April 2, 2026

RE: Building Permit Application for Satellite Earth Station Site Improvements
Site Address: 7113 Space Village Ave, Colorado Springs, CO 80929
APN: 5417001012
Zoning District: Industrial (I-3)
Starlink Project: Colorado Springs, CO GSN-2988

EROSION CONTROL PLAN

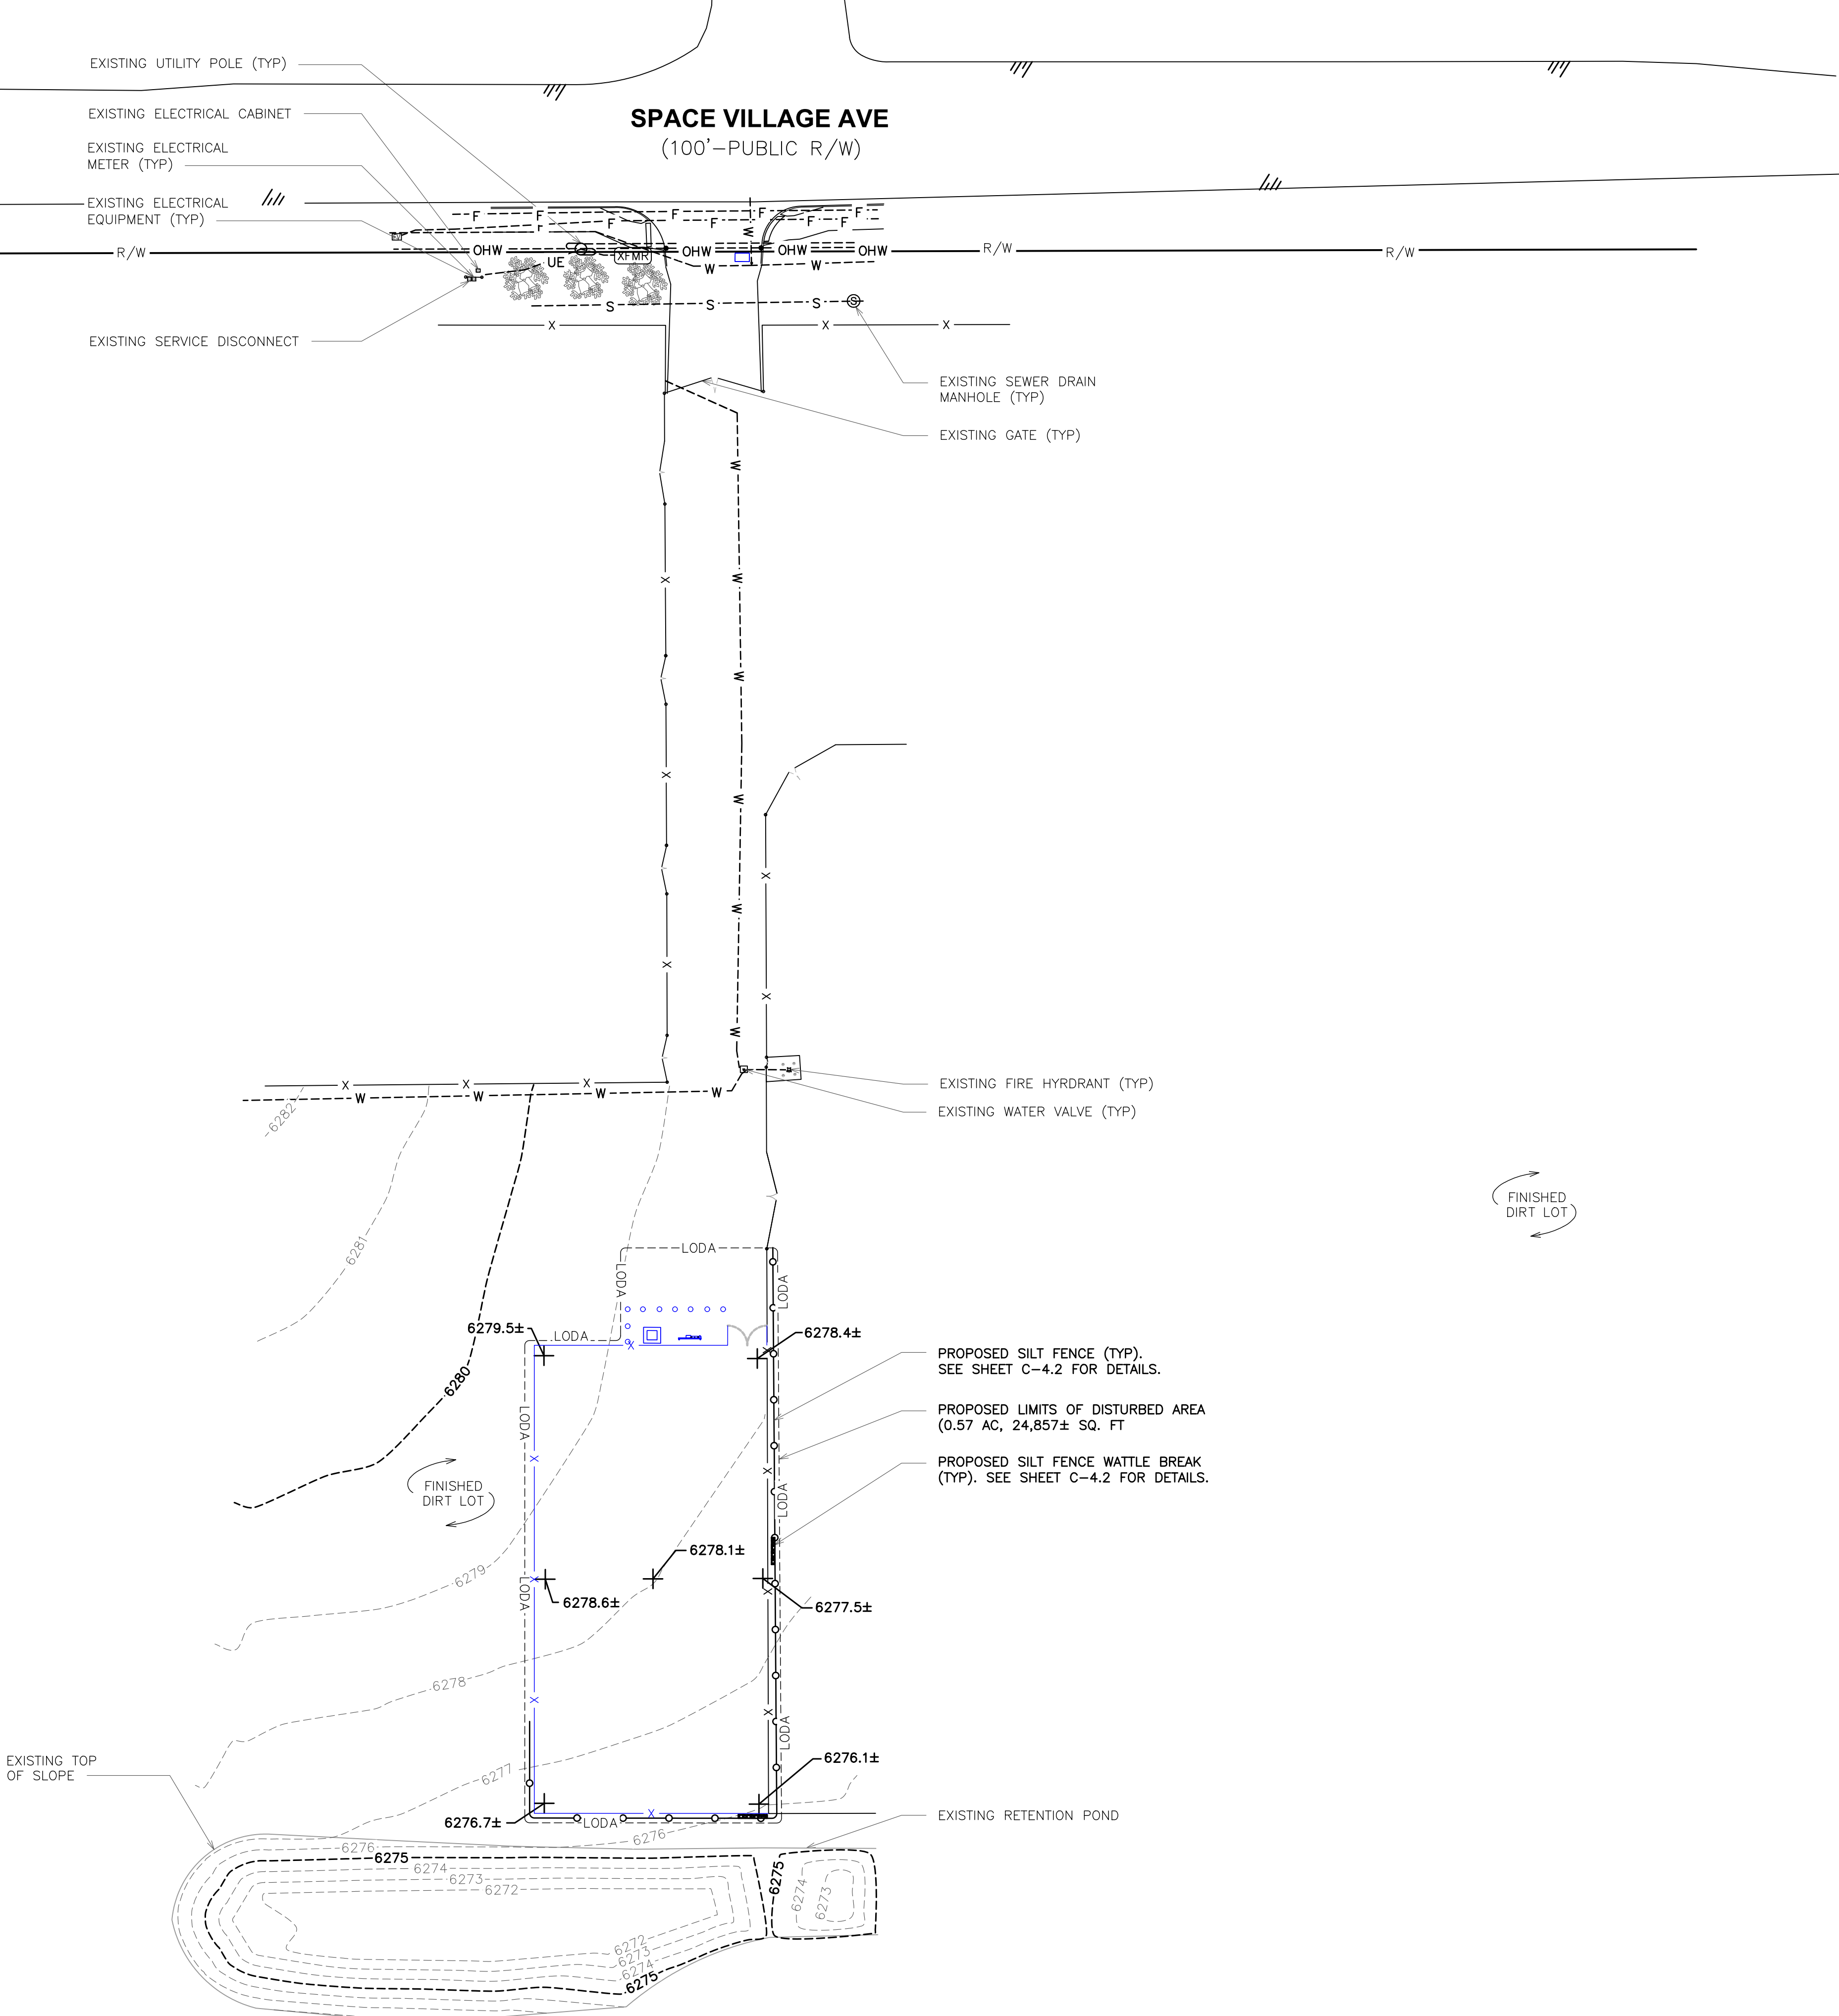
Please include a statement that stormwater runoff from the proposed satellite antennas will not adversely impact downstream or neighboring properties.

Please provide a statement and reasonable supporting calculations (ex: proposed impervious percentage, proposed peak runoff for 5/100 yr storms, etc.) confirming that the proposed development does not exceed the design assumptions of the stormwater pond that provides treatment for the site. See PCD Projects MS2227, PPR2528, and PPR233 for reference.
